1. REP6-034 Daniel Wimberley comments on Deadline 5 Submissions

Response reference:	DW Deadline 6 comments	National Highways Response at Deadline 7	DW Deadline 9 response
9.70.25	<p>Highways England, in their document 9.53, have submitted to this examination their replies to many of the points which I raised in my Deadline three submission. For the references for these two documents see the box above.</p> <p>For each reply which Highways England have made, I have copied in full both the extract which they copy from my DL 3 submission, to which they reply, followed by their reply. I then present my comments to their reply.</p> <p>My thanks go to Highways England for these replies as they enable the discussion to progress. Many important points are clarified in my comments to their replies. I have attempted to summarise the key points to emerge in the next section.</p> <p>Rather than tiptoeing around issues, as is commonly thought to be the English way, I have called the spade a spade where necessary. I think this gives a clearer view to the ExA and to other stakeholders of what the key differences of opinion, disagreements over facts, and attitude actually are.</p>	No response requ

Insert 11 Glossop AAWT Flow 2025

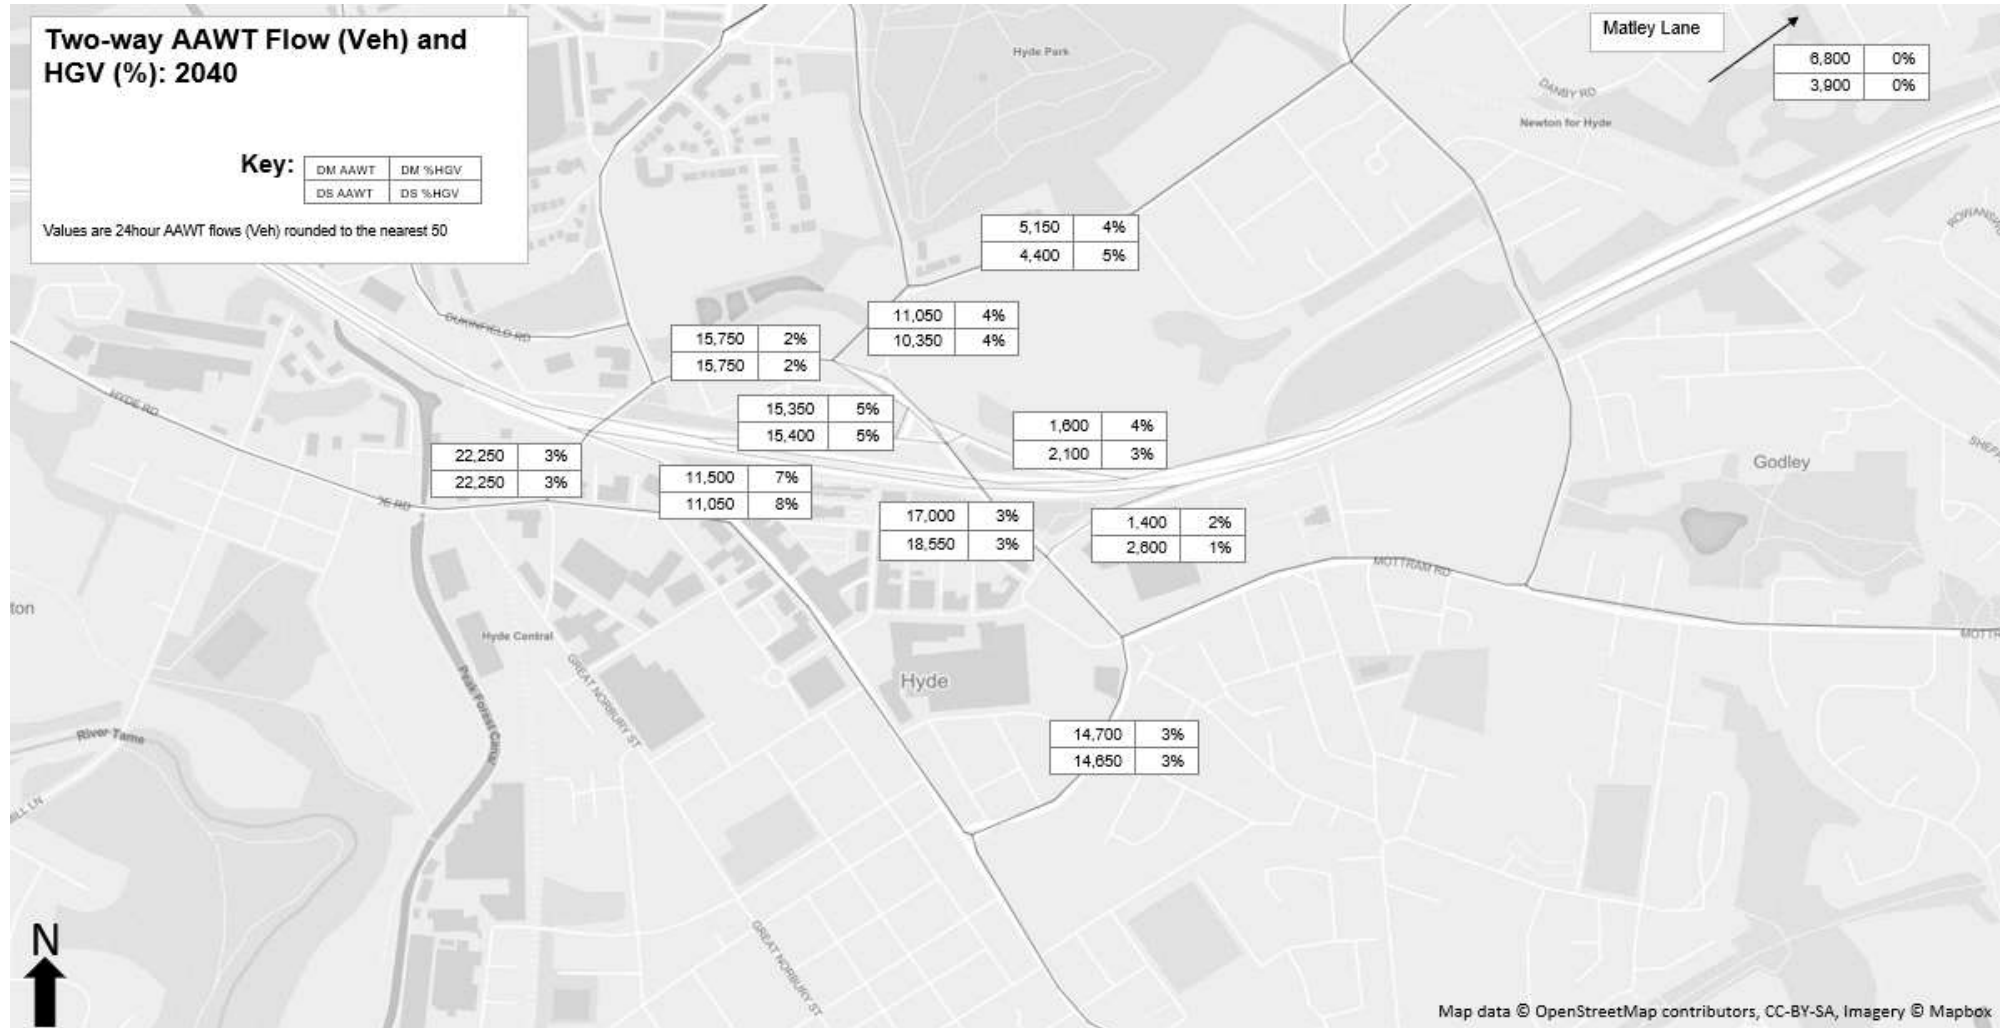
SIDE ROADS IN GLOSSOP DO SOMETHING (DS) versus DO MINIMUM (DM)

Shaw Lane	Dinting Road	Cemetery Road	Norfolk Street
2025-DM	6900	3100	5150	8200
2025-DS	7900	4500	5750	9900
percentage increase DS over DM	14.5%	45.2%	11.7%	20.7%
numerical increase DS over DM	1000	1400	600	1700

Data from ES App. 2.1, tabulated iirc by CPRE
DW NOTE: there are many side roads in Glossop NOT included in this table as the data for

Response reference:	DW Deadline 6 comments	National Highways Response at Deadline 7	DW Deadline 9 response
	<p>them has not been collected or modelled, or published, whichever is the case.</p> <p>To call an increase of 1000 vehicles per day on an existing flow of 6900, or an increase of 1400 on an existing flow of 3100 “relatively low” is – well, what is it? Choose your own adjective, and especially do this bearing in mind the implications of these increases (see next paragraph), and the nature of the roads we are talking about.</p> <p>To argue that they effectively make no difference is absurd. People waiting to cross the road, children walking to school and their state of mind as they do so, and their freedom, or lack of it, to enjoy the walk with their friends, the parents or guardians of those children worrying about their safety, and possibly even driving them to school so that their safety can be guaranteed, the intimidation effect of the additional traffic on all those who might adopt or be thinking of adopting active travel, the effect of the additional noise and pollution on people's physical and mental health, the potential impact on local shops and facilities, and the cumulative effect of all this on people's well-being; all this is of no concern to Highways England who declare that no mitigation is required. And as if all that were not enough, HE themselves predict increased accidents along just 2 of these roads to the tune of between £.5 million and £1million in monetised costs, if the scheme were to be built (source: HPBC LIR paragraph 7.33. It should be noted that this information also is nowhere to be found in the TAR. Itn does not feature in the Case for the Scheme either. In fact the CftS goes a step further. Referring to accidents, it states that on “residential roads” the scheme “is not expected to have an impact” . (paragraph 4.5.2). This is perilously close to lying, is it not?</p>
